Re: Frank Sanchez Warehouse
2339 2nd St. NW
Request Permanent CO - Accepted
Engineer's Stamp dated: 12-8-15 (M14D029A)
Certification dated: 4-12-16

DRAINAGE AND TRANSPORTATION INFORMATION SHEET (REV 09/2015)

From: Elliott, Stanice
Sent: Tuesday, April 26, 2016 4:59 PM
To: 'Philip Clark'
Subject: RE: Frank Sanchez Warehouse
Attachments: IMG_1027.JPG; IMG_1028.JPG

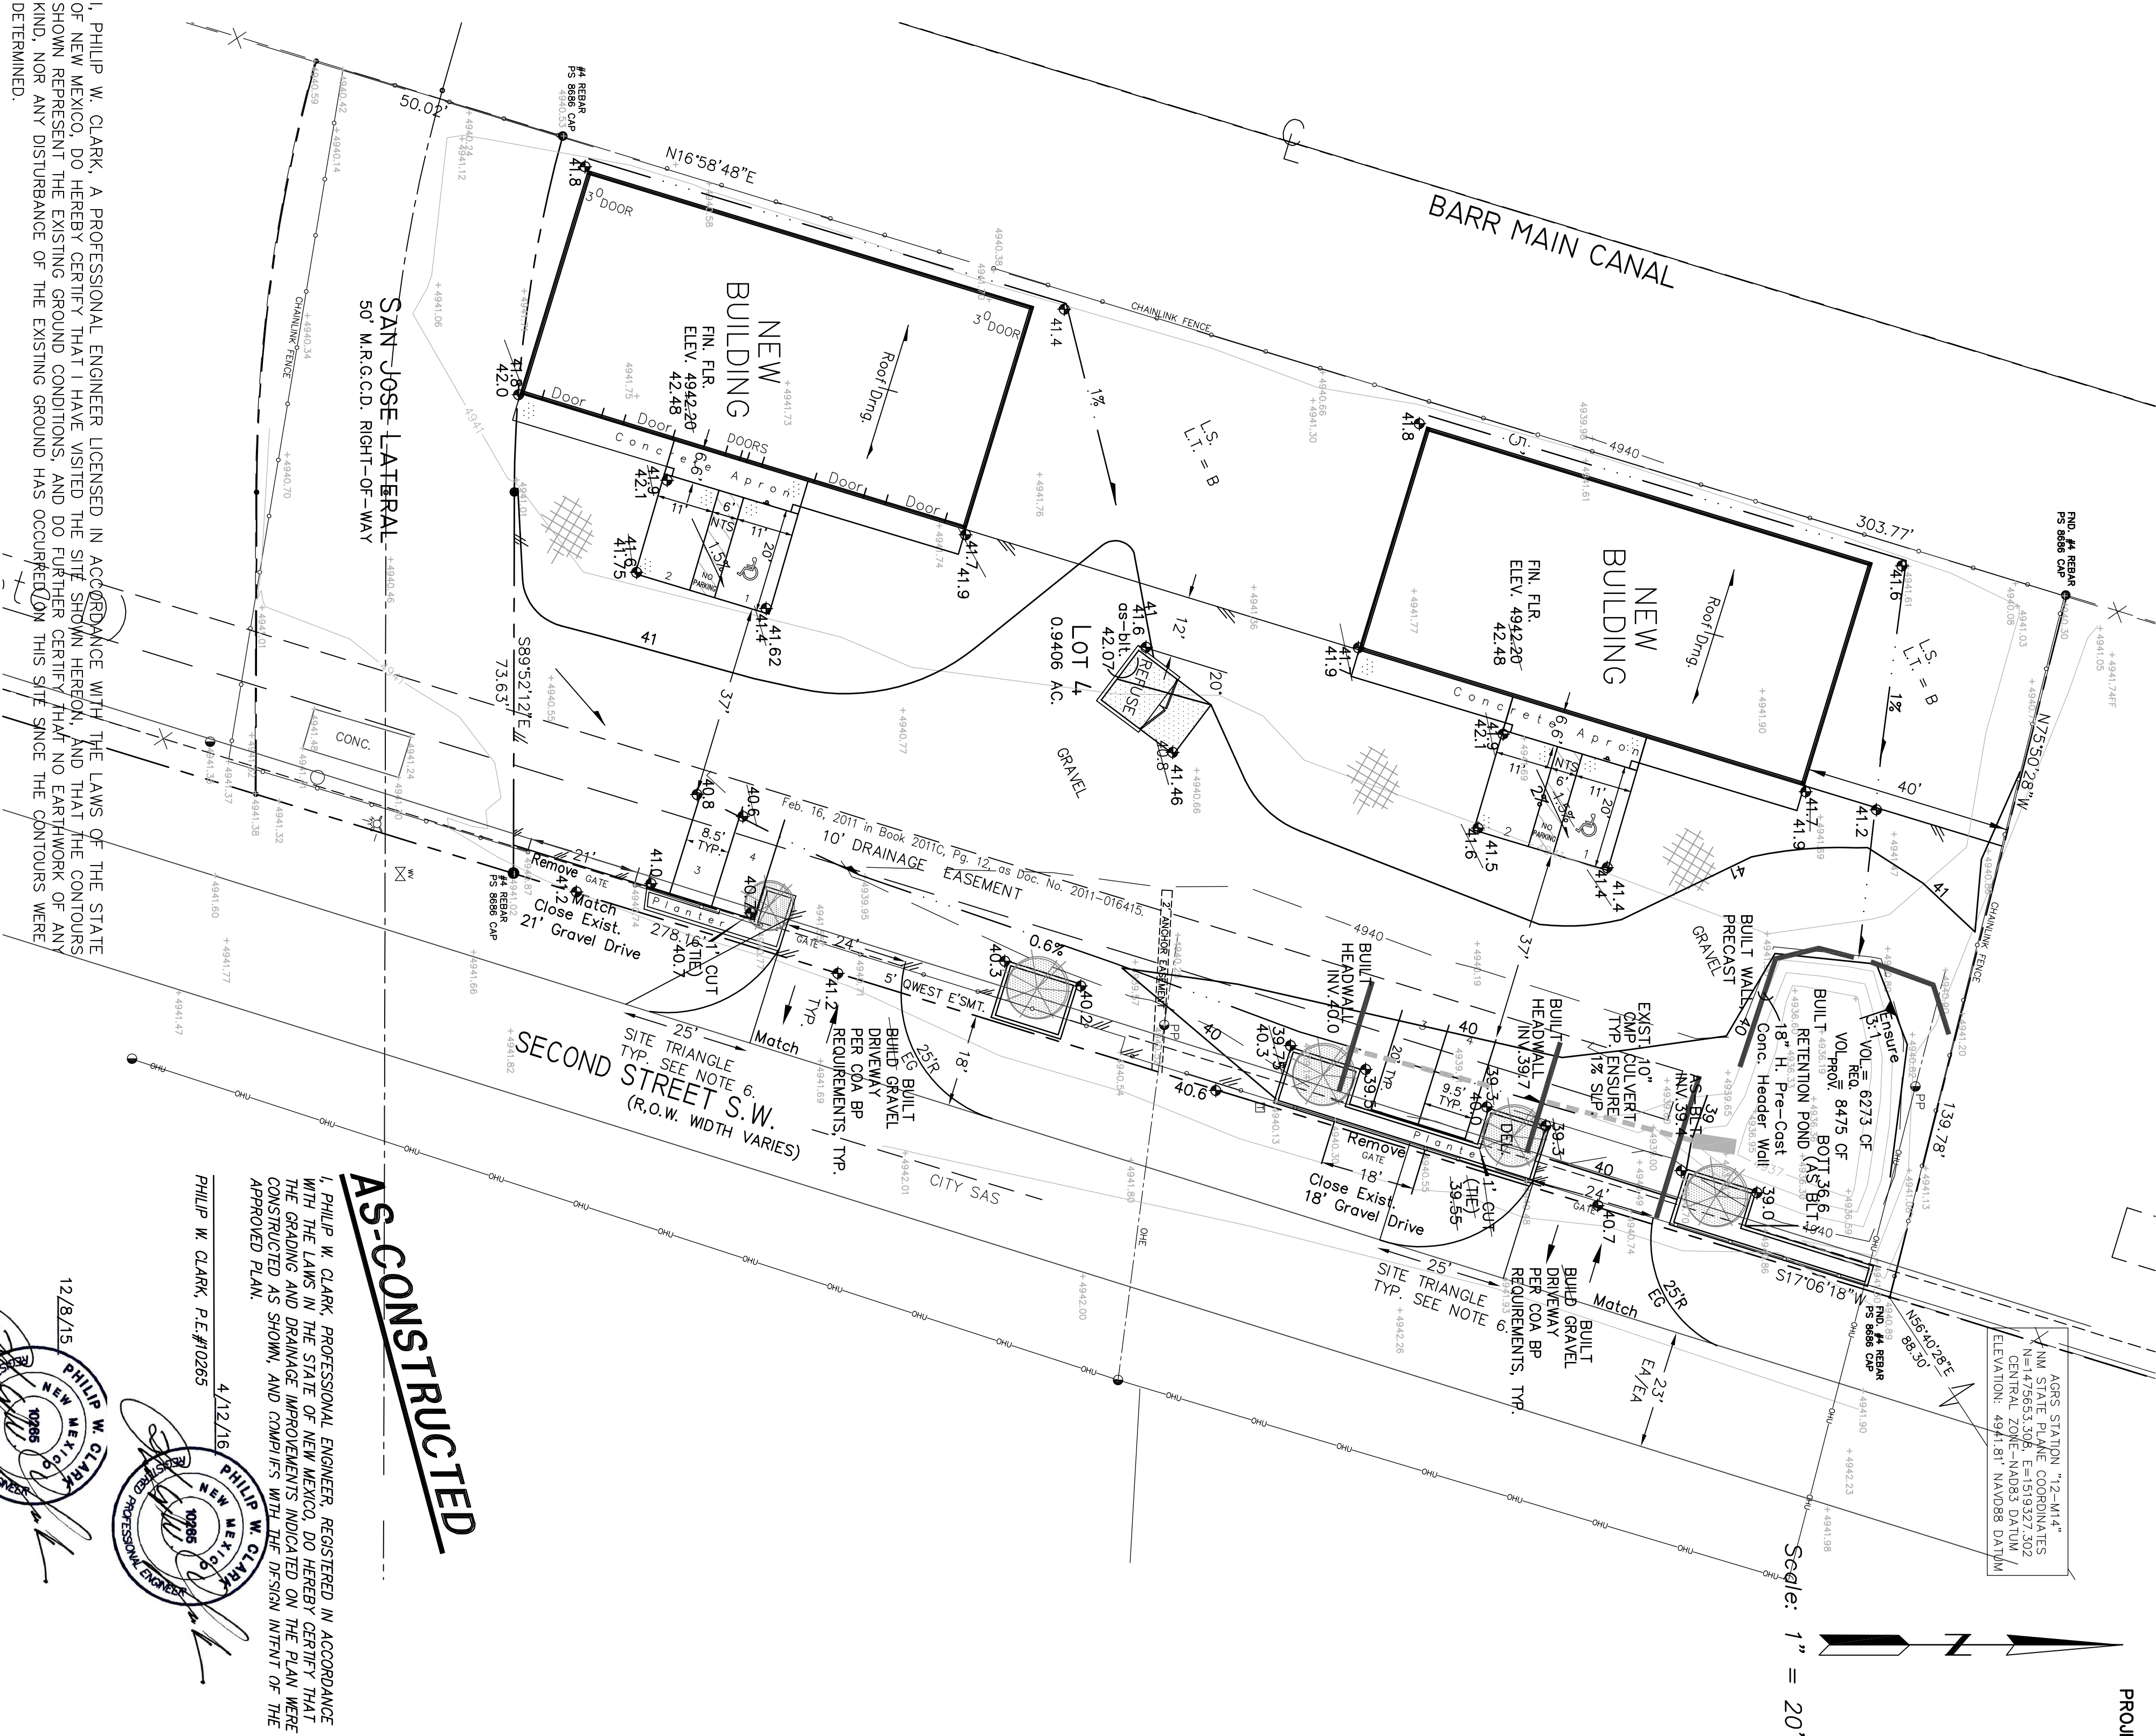
- The debris must be removed from the pond. See attachments.

Before a permanent CO can be accepted the above mentioned comment must be addressed.

Stanice...I thought your name was Tottem...sp?.....anyway spoke with owner he will be back Monday and will clean debris ...asap.
